**KIRKLEES METROPOLITAN COUNCIL  
TOWN AND COUNTRY PLANNING ACT 1990  
HIGHWAYS DEVELOPMENT CONTROL KP20H**

**PLANNING REF** 2012/62/92626/W0/JS  
**CATEGORY** Minor

**PROPOSAL** ERECTION OF ONE DETACHED  
DWELLING WITH INTEGRAL  
GARAGE(MODIFIED PROPOSAL)

**LOCATION** CROSSWAYS  
NIELDS ROAD  
SLAITHWAITE  
HUDDERSFIELD  
HD7 5HT

Drawing title Plans & Elevations as
 Proposed and Site Layout

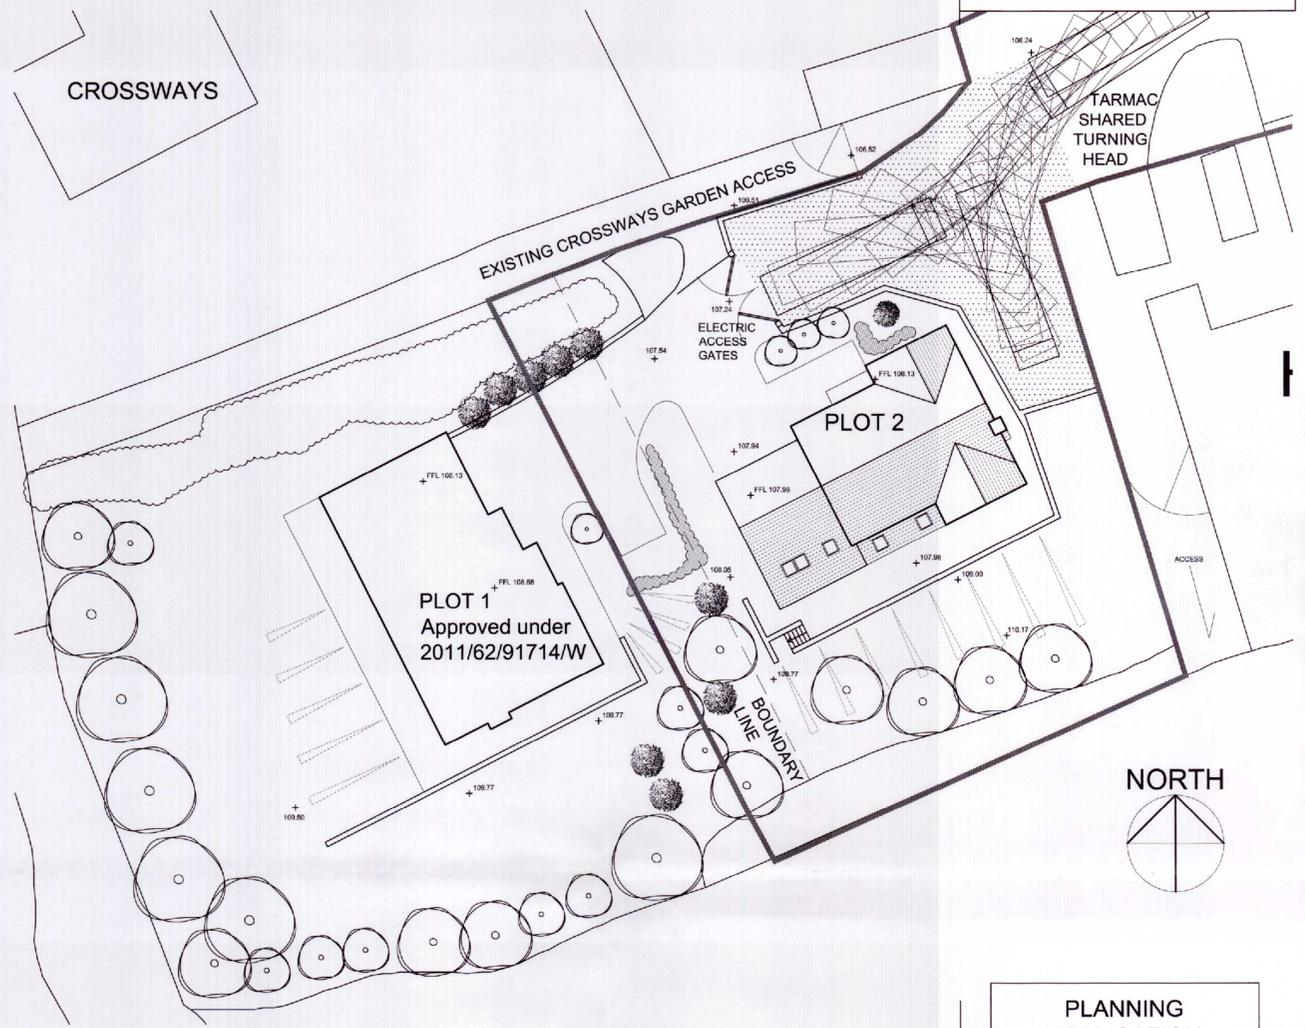
The location of the proposed development is at the head of the cul-de-sac and access from the site is directly onto Spring Street. It is noted that visibility at this point is acceptable as there are no direct vehicular conflicts other than an adjacent garage.

A previous planning consent on this site for one dwelling was subject to providing a service vehicle turning area, which was seen to give improvements to residents/users of Spring Street and gave weight to removing highway objections on balance.

With respect to the current proposal for 1 dwelling, the proposal does not add any highway benefit to the substandard nature of Spring Street. As such, it is considered that the proposal would lead to the deterioration in the local highway conditions both in terms of convenience and safety contrary to UDP policies D2 and T10 of the Kirklees Unitary Development Plan.
